Re: Traffic Noise Assessment Cover Letter  
2710 Draper Avenue, Ottawa ON  
GWE File No.: 17-059- Cover Letter- July 24 2019

Following our submission of a traffic noise study for the proposed residential subdivision located at 2710 Draper Avenue in Ottawa, Ontario (ref. Gradient Wind report #17-059 - Traffic Noise Final R2, dated November 2, 2018), this brief letter addresses comments from the City of Ottawa regarding the proposed noise barrier located within the rear yard of Block 11.

SOUND BARRIER DETAILS

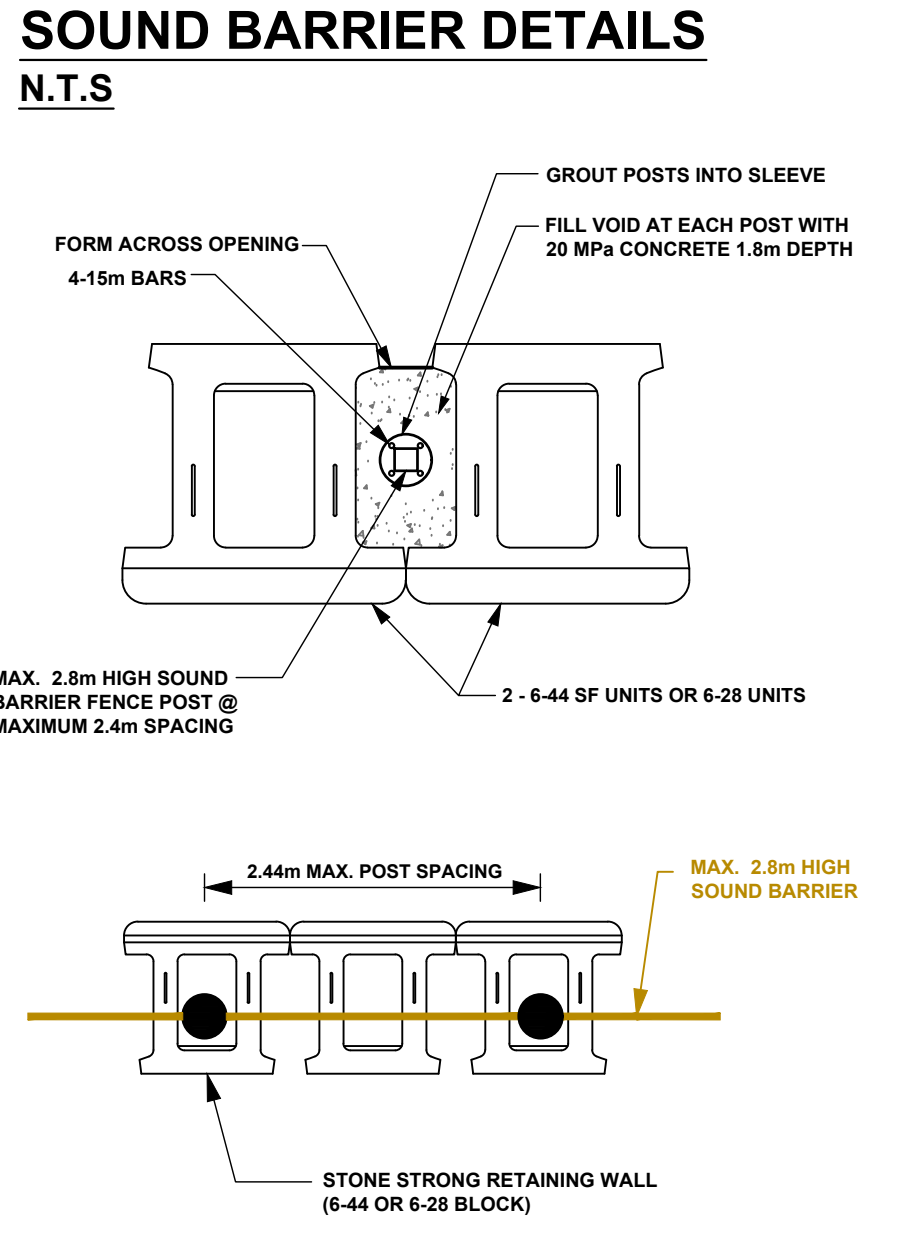
1. *As per the Traffic Noise Assessment prepared by Gradient Wind Engineering Inc. dated November 2, 2018 a 2.82m noise barrier is located within the rear yard of Block 11. Rear yard drainage and the rear yard overland flow route is impacted by the location of this proposed noise barrier. No details have been provided on the plan. As per the Environmental Noise Control Guidelines (January 2016) acoustic barriers should have no gaps or opening in a noise barrier. If a gap or small opening is being proposed to accommodate rear yard overland flow this would be considered a deviation requiring cover letter to be submitted from the noise consultant for review and approval stating the deviation, the reason/justification for the deviation and further analysis completed with a gap modelled within the noise barrier. Noise barrier details are required be provided on the plan.*

Subsequently since submitting our addendum letter dated May 31, 2019, the City in their comment letter dated July 3, 2019 have since asked for barrier details and modified warning clauses as related to comments 41 and 42.

Below is the modified warning clause for Block 11 and conceptual details of the noise barrier are provide in Figure 4. The structural details of the noise wall will need to be reviewed by a qualified structural engineer prior to construction of the wall. Shop drawing of the noise wall should be provided to Gradient Wind for approval prior to construction.
